SCOPING OPINION:

Proposed Lime Down Solar Park

Case Reference: EN010168

22 August 2024

Scale: 1:30,000 @ A3

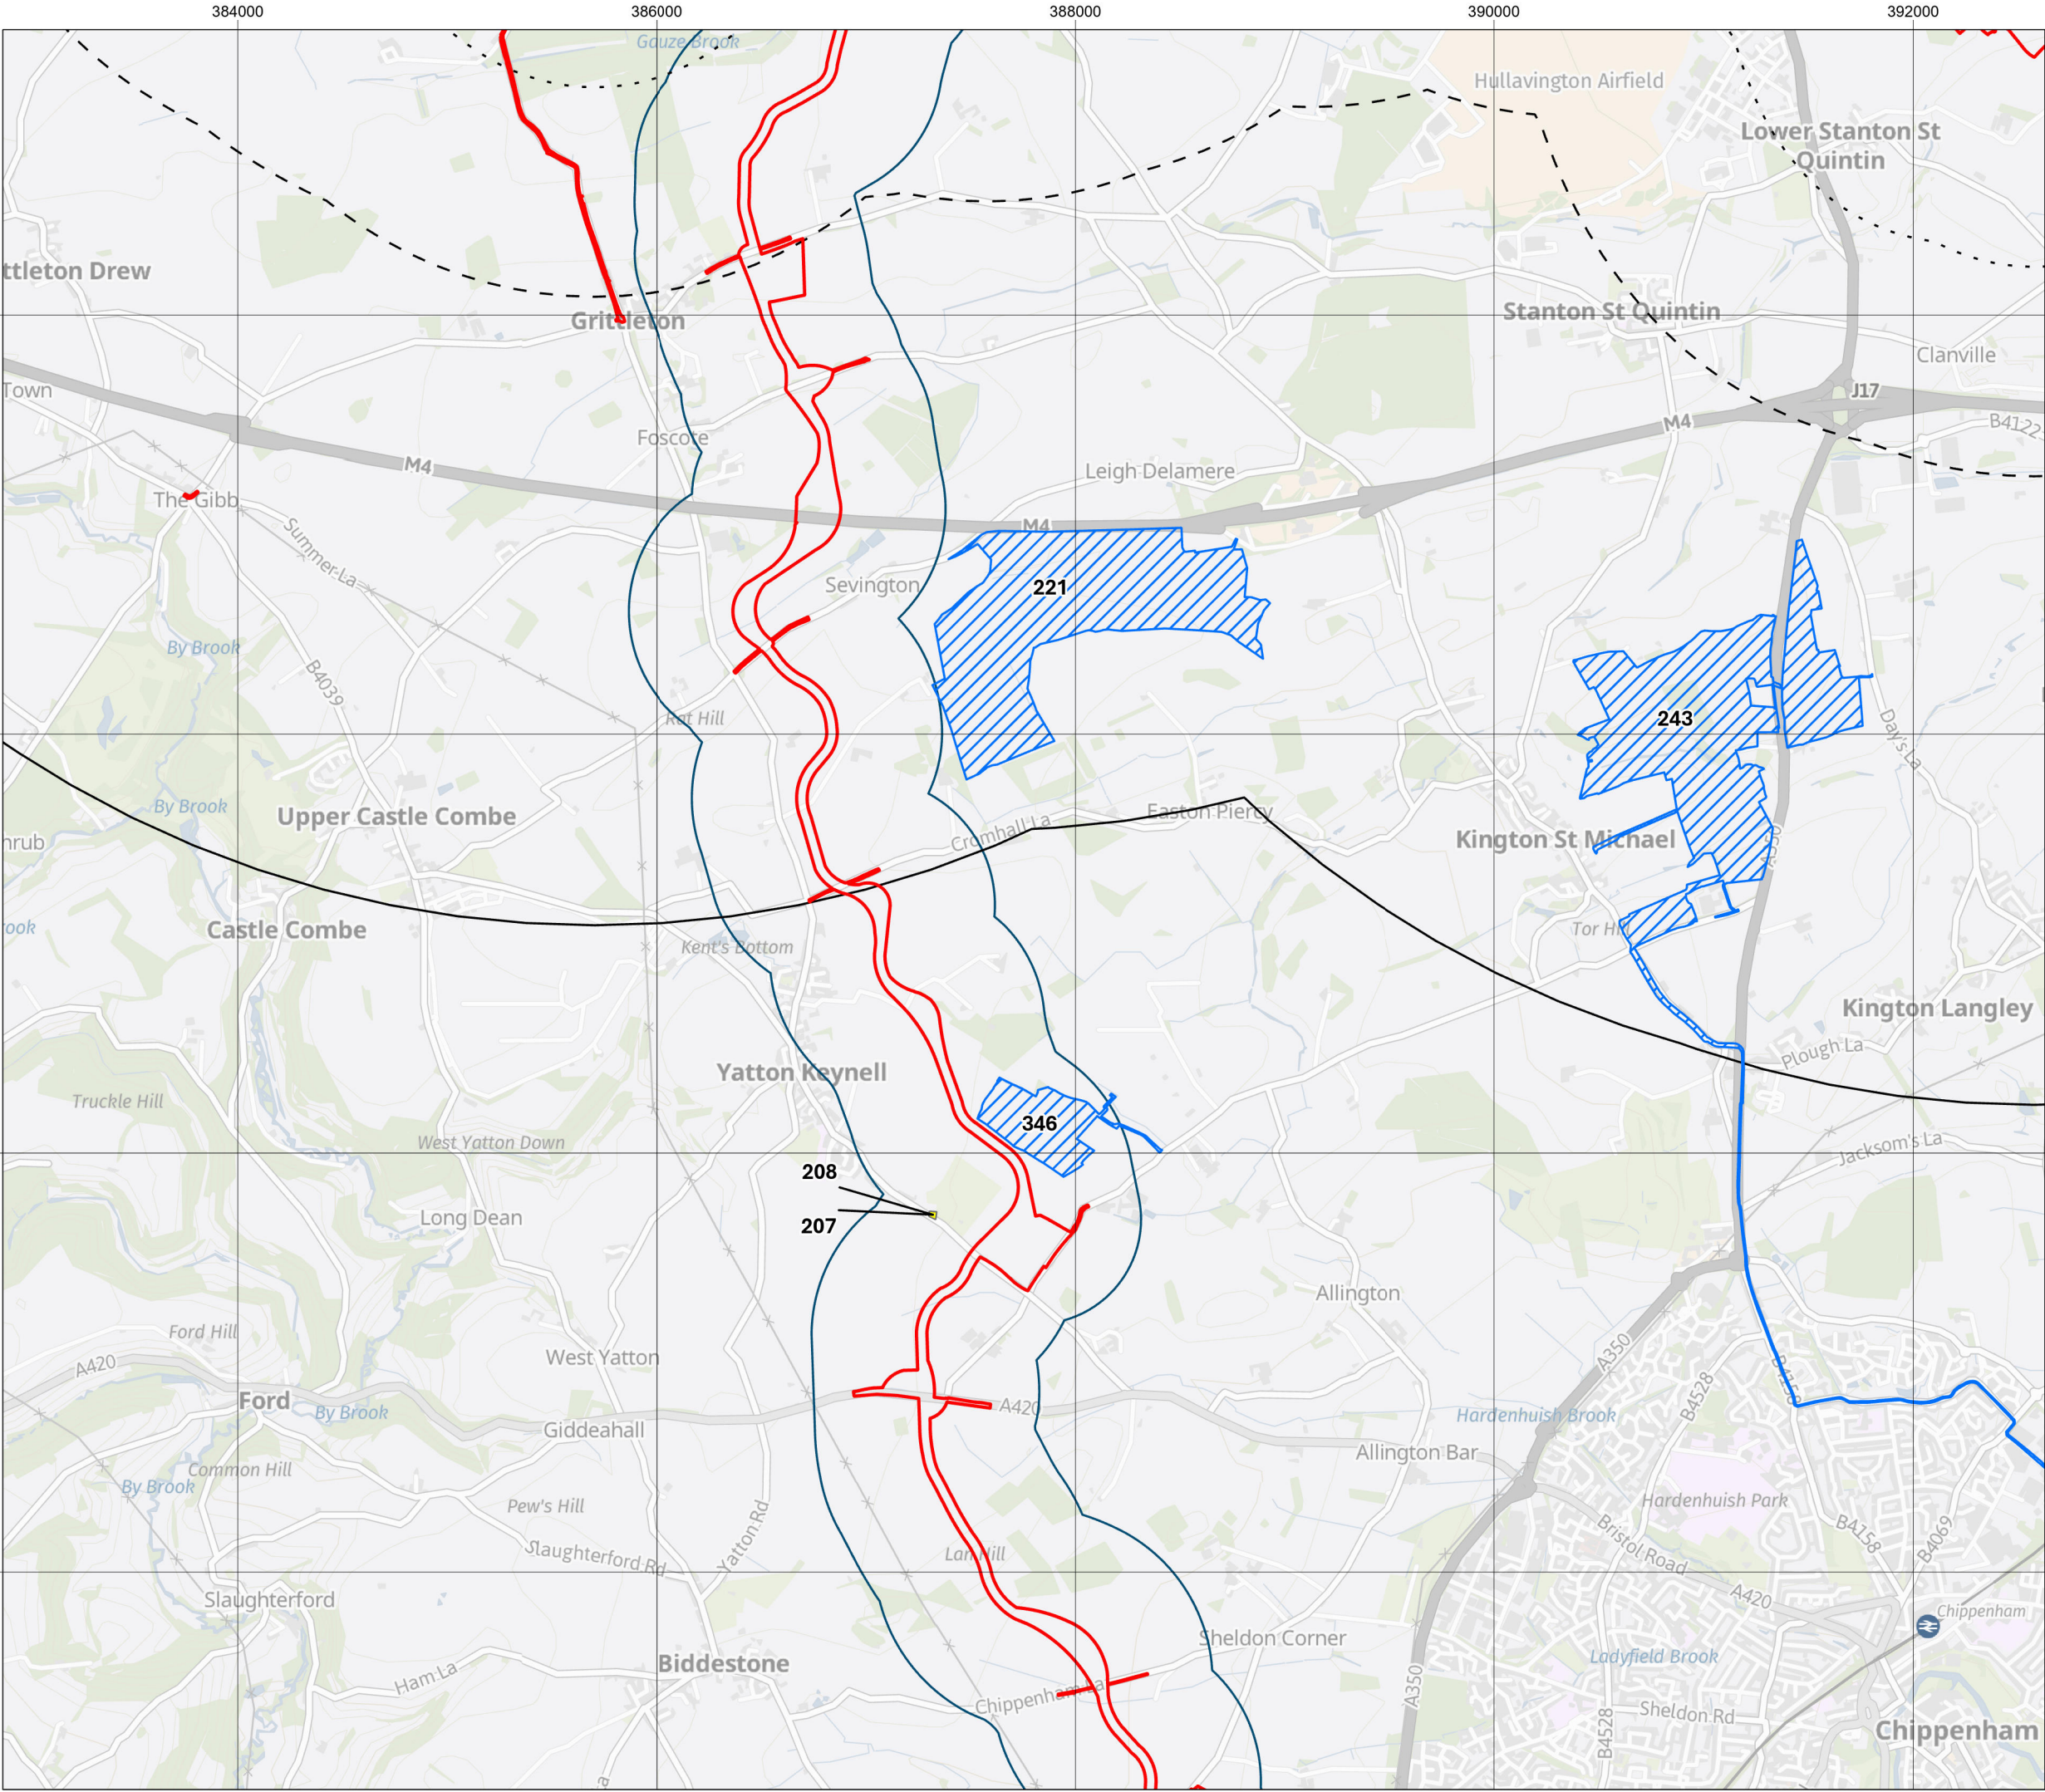
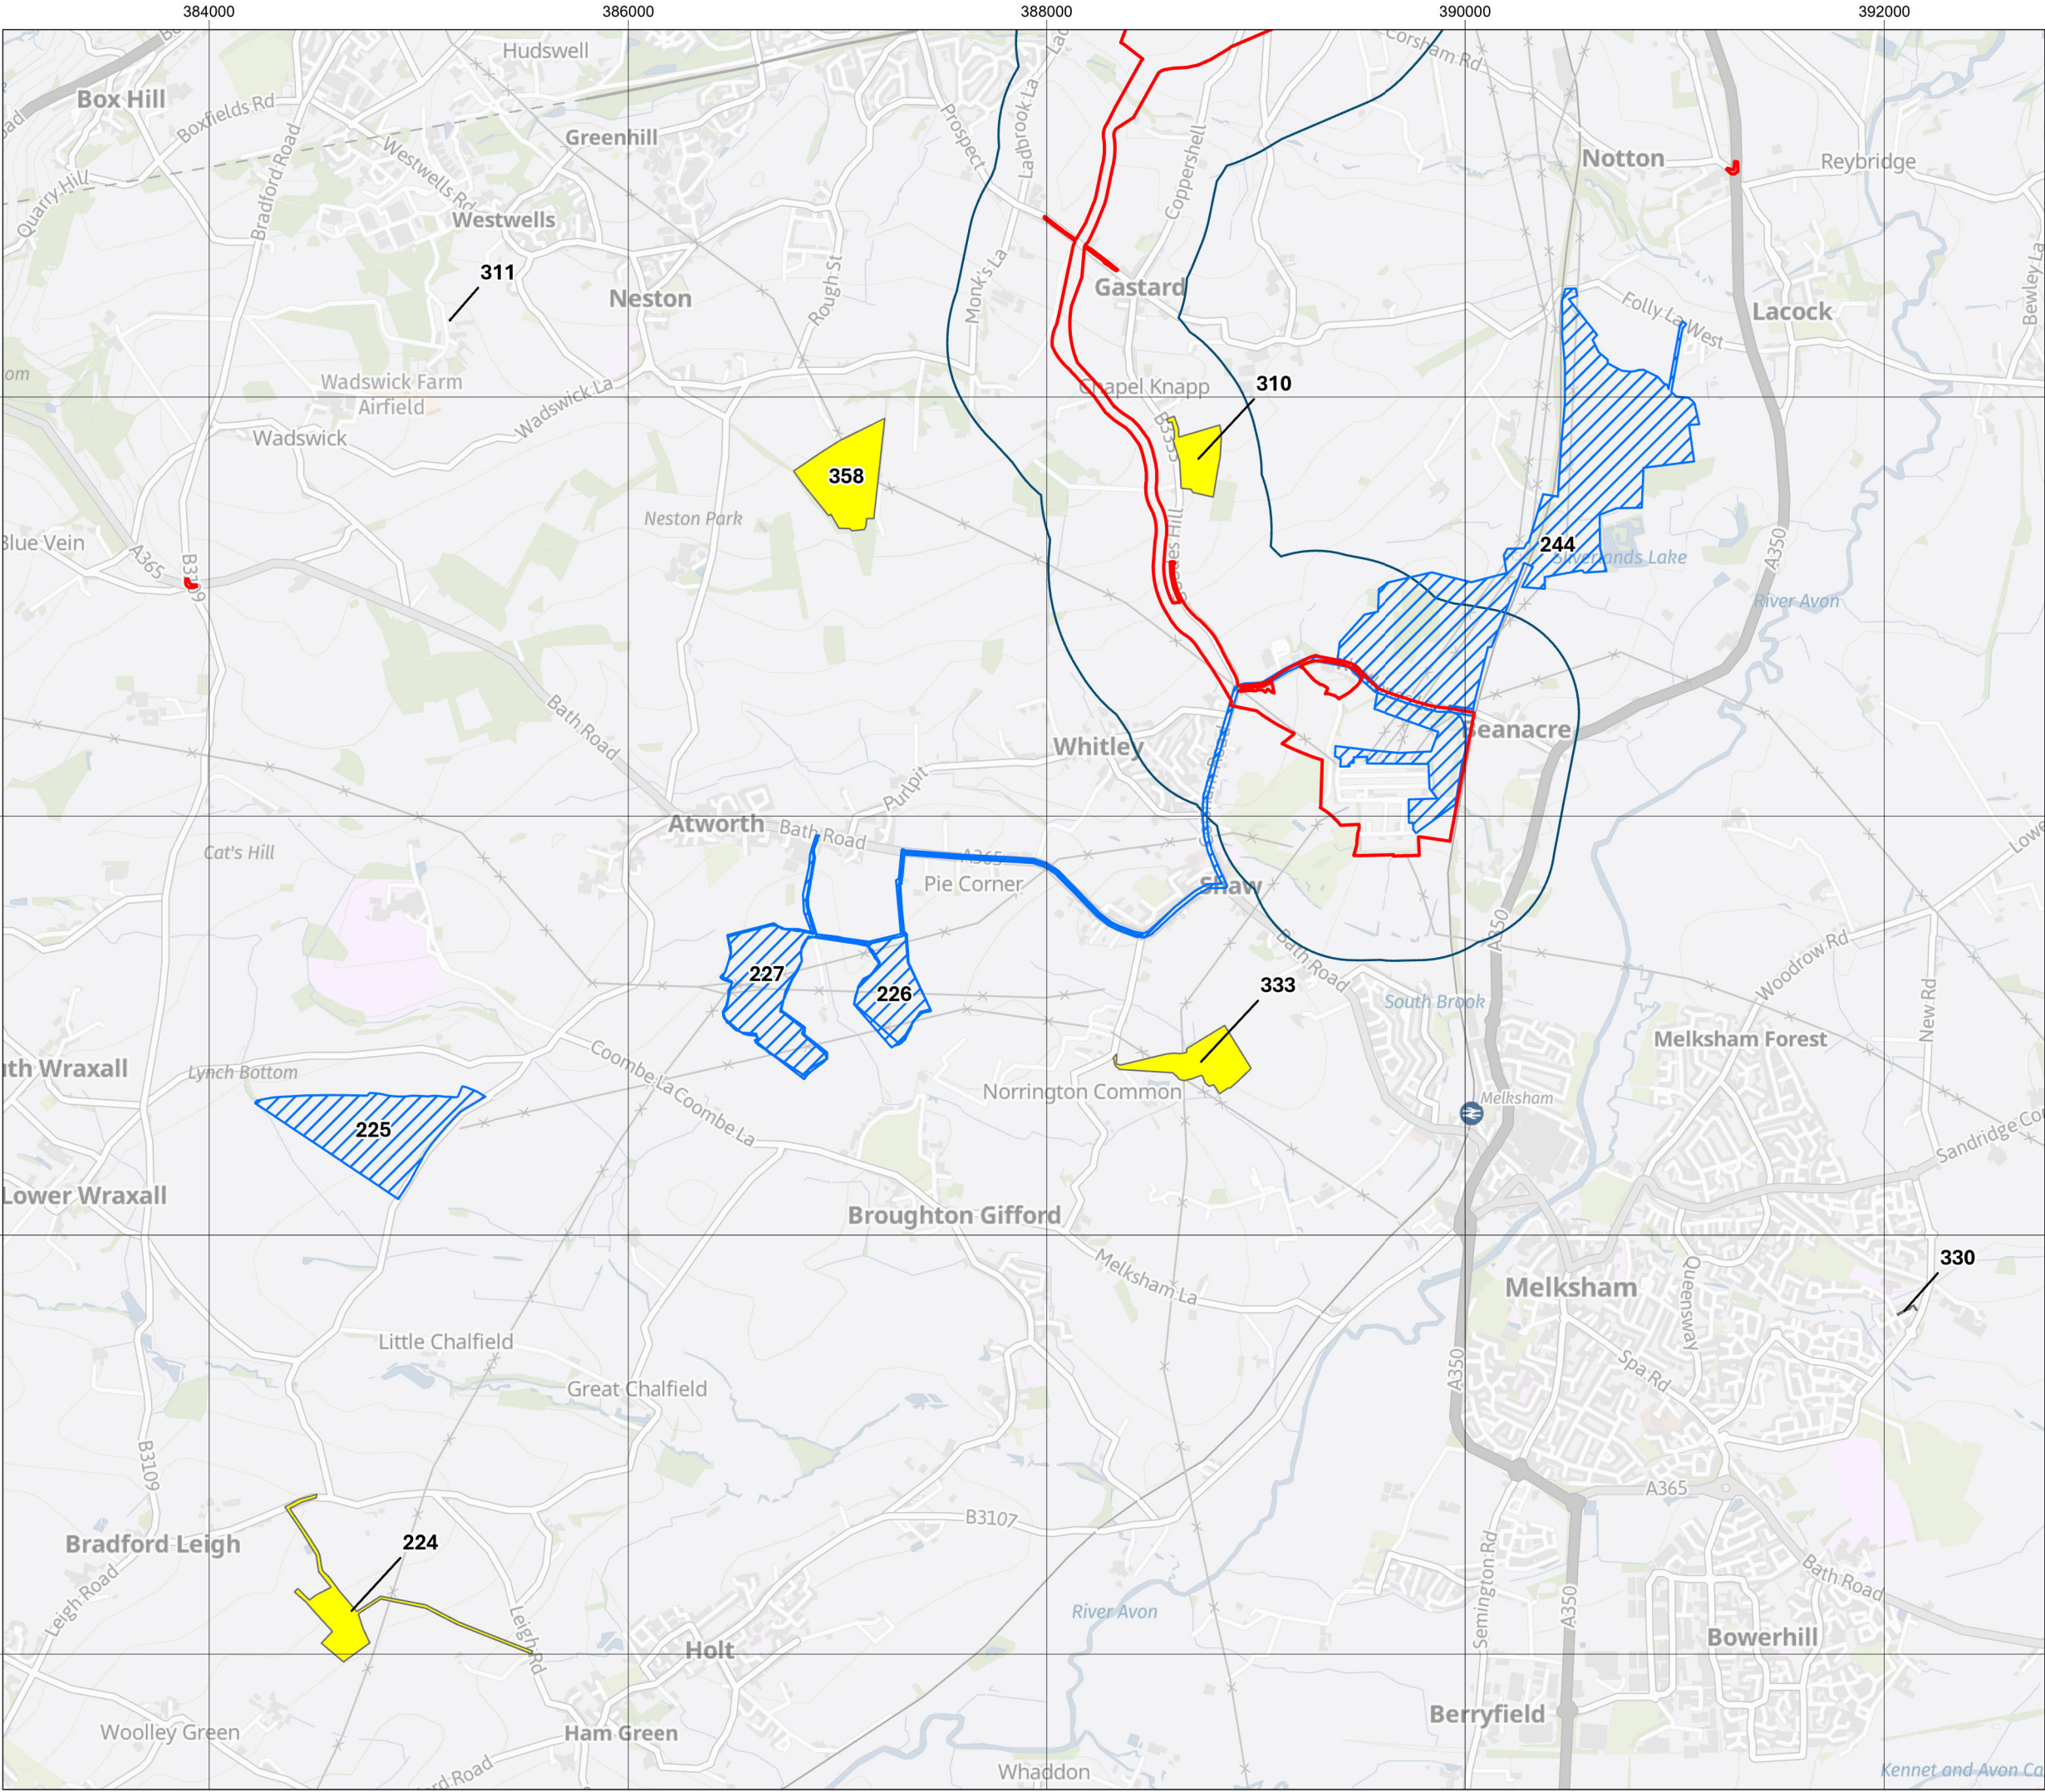
ID	Ref	Description	Inspectorate's comments
221	Para 2.2	Cumulative Effects Assessment (CEA)	The ES should include information on the location of the developments included in the CEA and the distance from the Proposed Development. This should be supported by a figure depicting the locations and extent of cumulative developments in relation to the Proposed Development.
222	Para 2.2.18 and 2.3.7	Reporting of significant effects	The Scoping Report states that the ES " <i>will highlight residual effects which remain following the implementation of suitable mitigation measures</i> ". The Inspectorate considers that the significance of effects prior to the implementation of mitigation measures should also be reported. This is to enable an understanding of the anticipated effectiveness of mitigation measures.
223	Para 2.3.5	Mitigation	The Inspectorate notes that various outline management plans, which will contain proposed mitigation measures, will be submitted with the DCO application. The outline plans should be sufficiently detailed to provide confidence in the delivery of mitigation, particularly that relied upon within the ES to avoid or reduce significant effects.
